Subject: RE: Planning Consultation on FP/42/19/DOC

Engineers Comments Regarding Condition 7

Project: Wellers Close Hampshire Homes Group	
Drawing: Soft Landscaping Concept	
Date: May 2018	Drawn by: JA
Scale: 1:200 @ A1	Revision: -

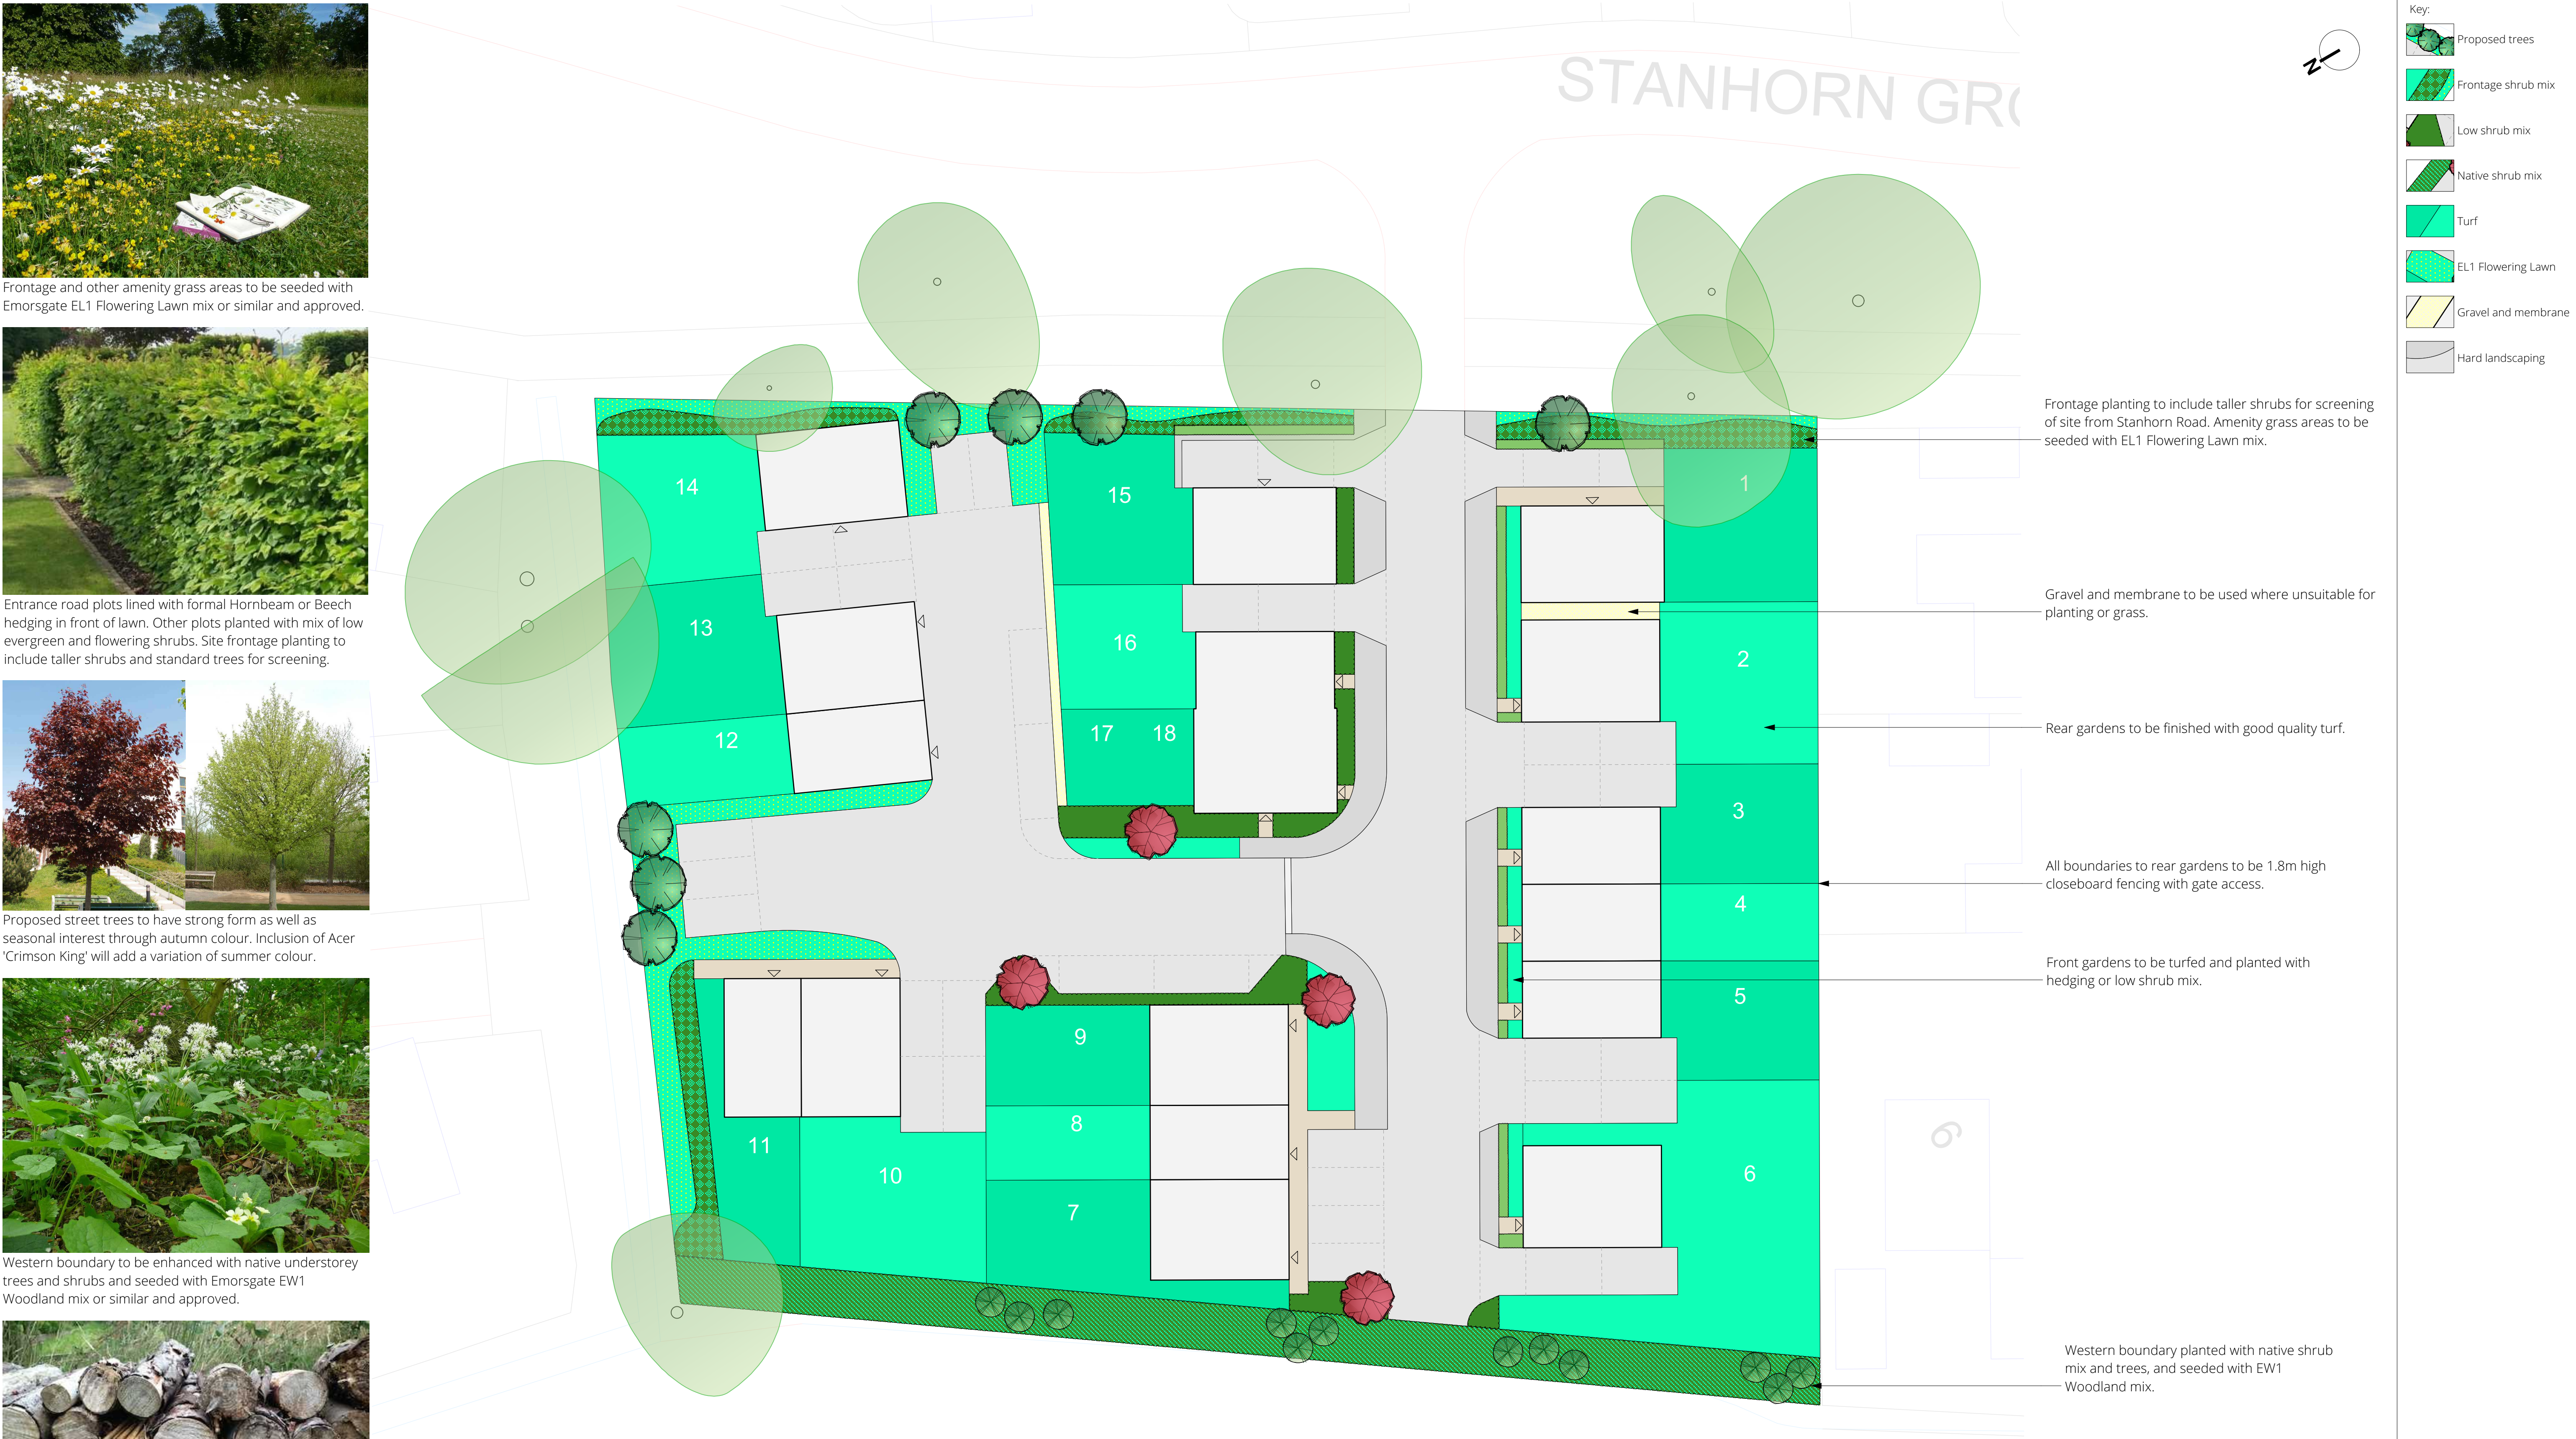
3. There is conflict between the landscaping proposals and the drainage proposals. Trees must not be located on or near attenuation tanks. Please revise the landscaping proposals.
Consideration has been made, nevertheless the proposed attenuation tank is located within the carriageway. A note has been added to our engineering layout stating no trees should be planted within close proximity of to the proposed attenuation tank.

Rev.	Date	Note	Author	Checked
A	11/06/19	De-mountable fence indicated to rear of Plots 12 - 14	RR	JP

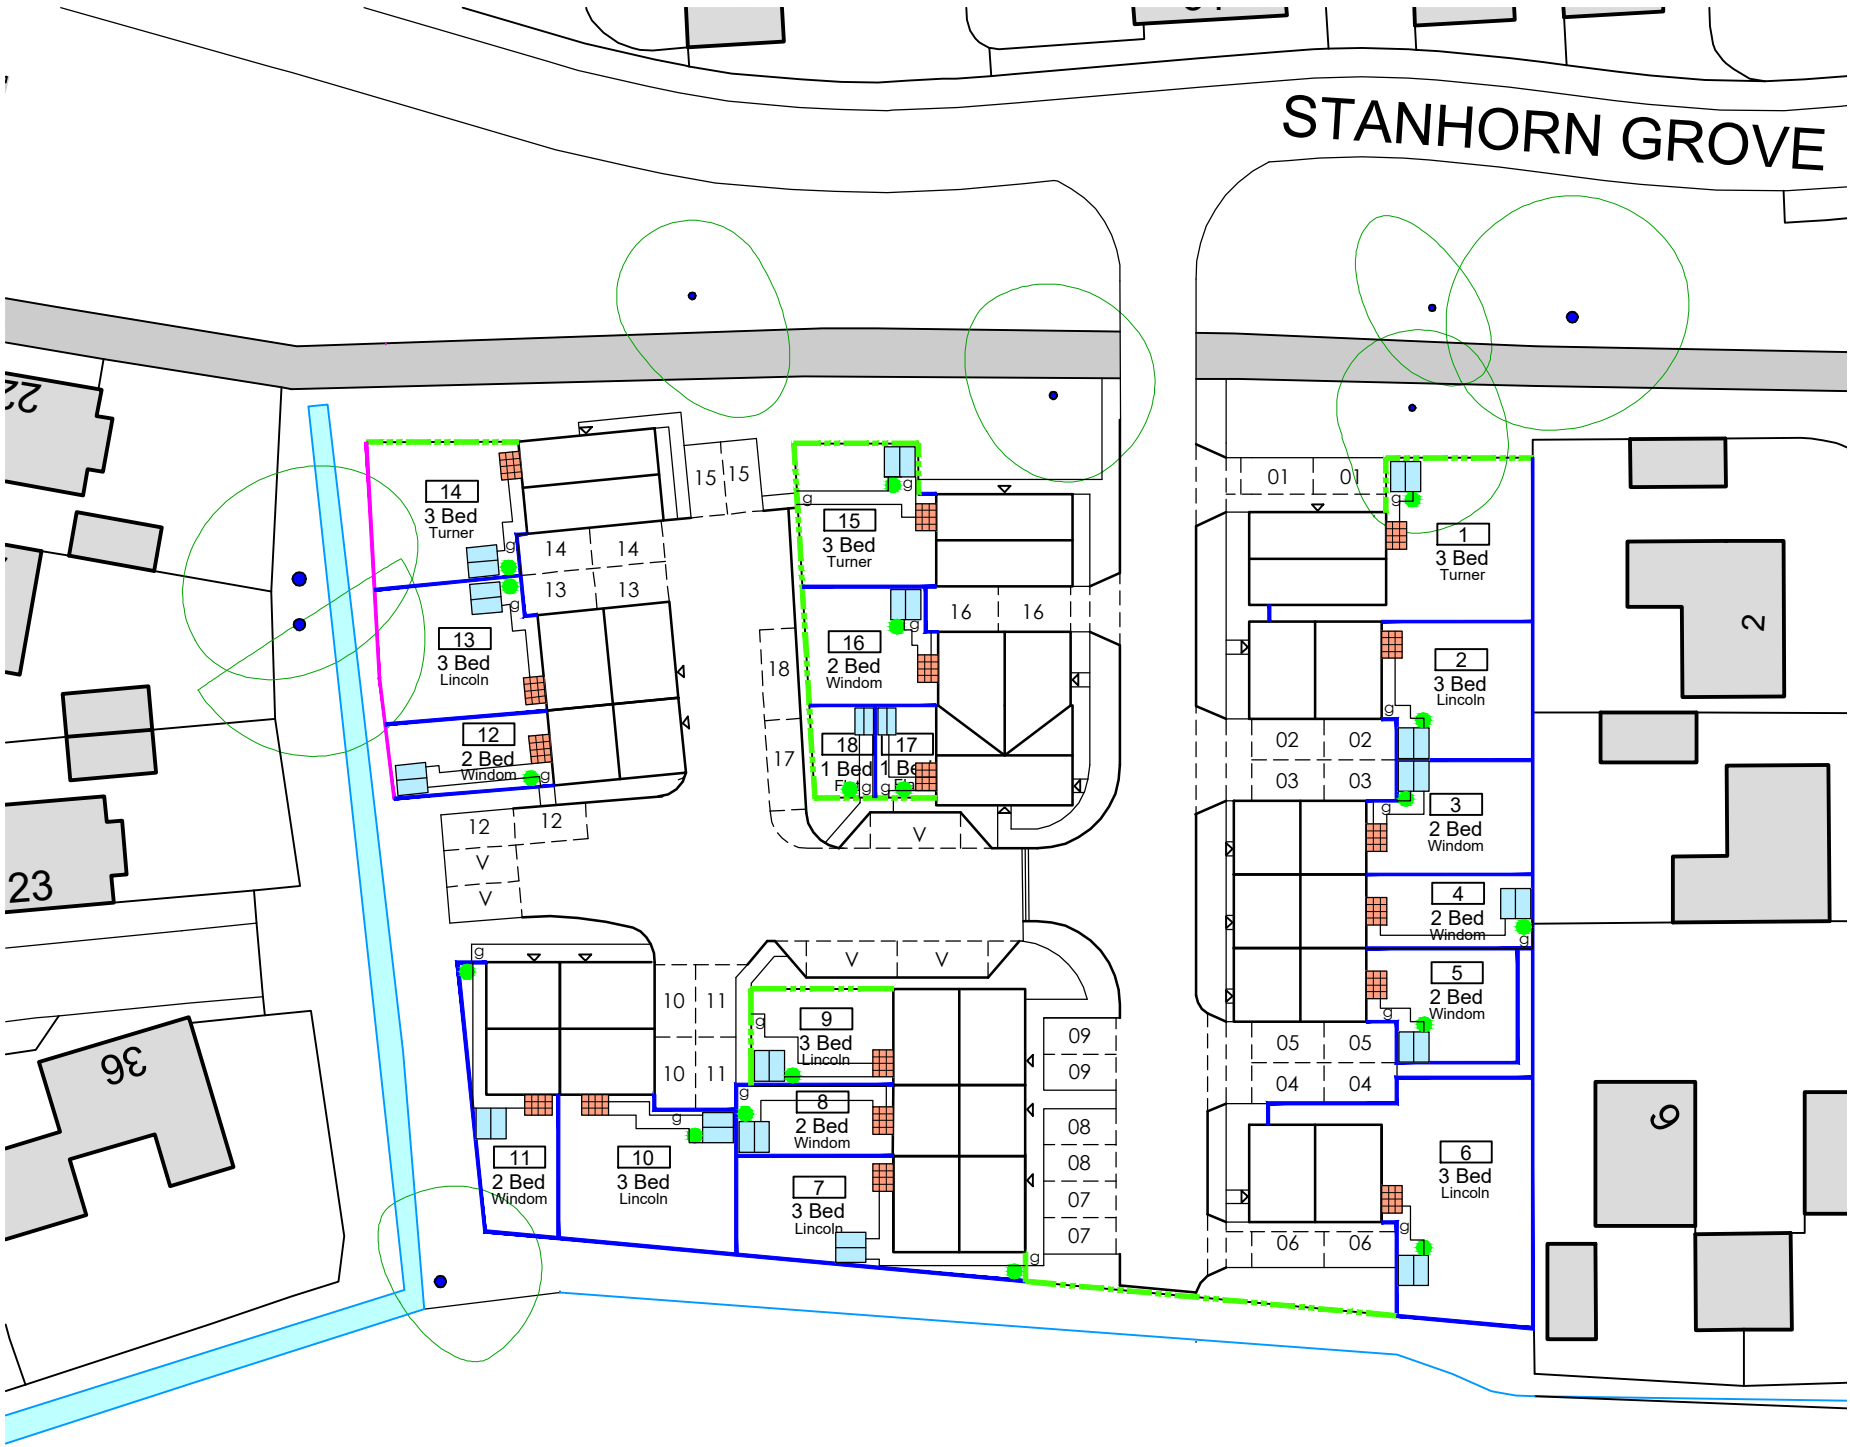
1. The construction detail drawings of the attenuation tanks needs to show the impermeable membrane around the tank, between the tank and the coarse sand bedding.
2. Can the catchpits please be labelled on plan.
3. 3m easement is not being provided to the watercourse at plots 12, 13 and 14. Please can this be provided. Or as a minimum demountable fences provided.
4. Please can the proposed landscaping plans be amended to remove the trees at the end of the parking area between plots 12 and 11/10? Trees are proposed directly in the location of the control chamber and in close proximity to the lined tank.

Proposed property boundaries for plots 12-14 need to be amended to allow access to the watercourse. 3m easement is required from any building, fence or wall and the top of bank of an ordinary watercourse.
